From: Dubyk, Wally <Wally.Dubyk@ottawa.ca>
Sent: Tuesday, May 01, 2018 8:06 AM
To: Jack, Ronald
Cc: Renaud, Jean-Charles
Subject: 129 Main St - Site Plan Application re-submission
Attachments: Transportation Comments - 129 Main St.docx

**129 Main Street
Screening Form (Dated April 26, 2018)
Site Plan SP-1, Revision #12, Dated April 03, 2018**

D07-12-10-0196

Figure 10: Site Plan

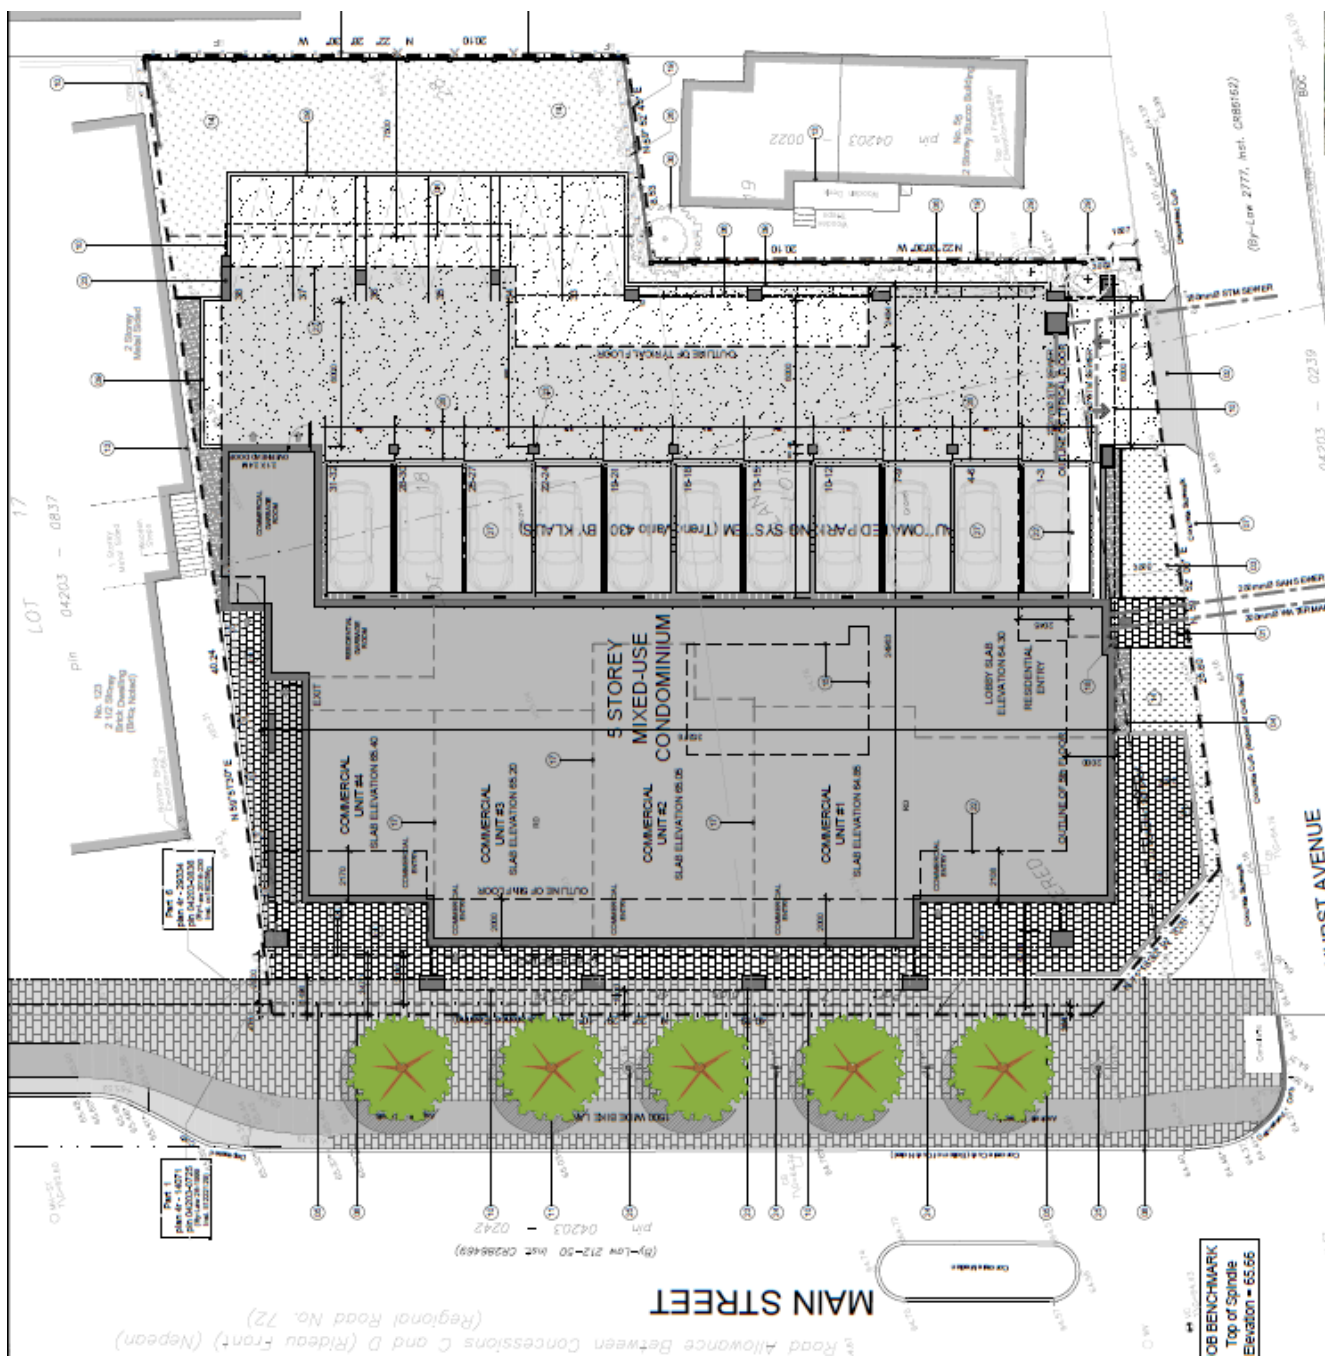
Main Street is designated as an Arterial road within the City's Official Plan with a ROW protection of 20.0 metres and an offset distance of 10.0 metres.

Permanent structures such as curbing, stairs, retaining walls, underground parking foundation and bicycle parking racks are not to be within the City's right-of-way limits.

Ensure that the pedestrian sidewalk has a clear and non-obstructive path of 2.0 metres width minimum. Any sidewalk width encroachment into private property will require an easement.

For the interlock pavers, landscaped areas and public art on City's road right-of-way the developer has to sign a "Maintenance Agreement" with the City to cover any claims.
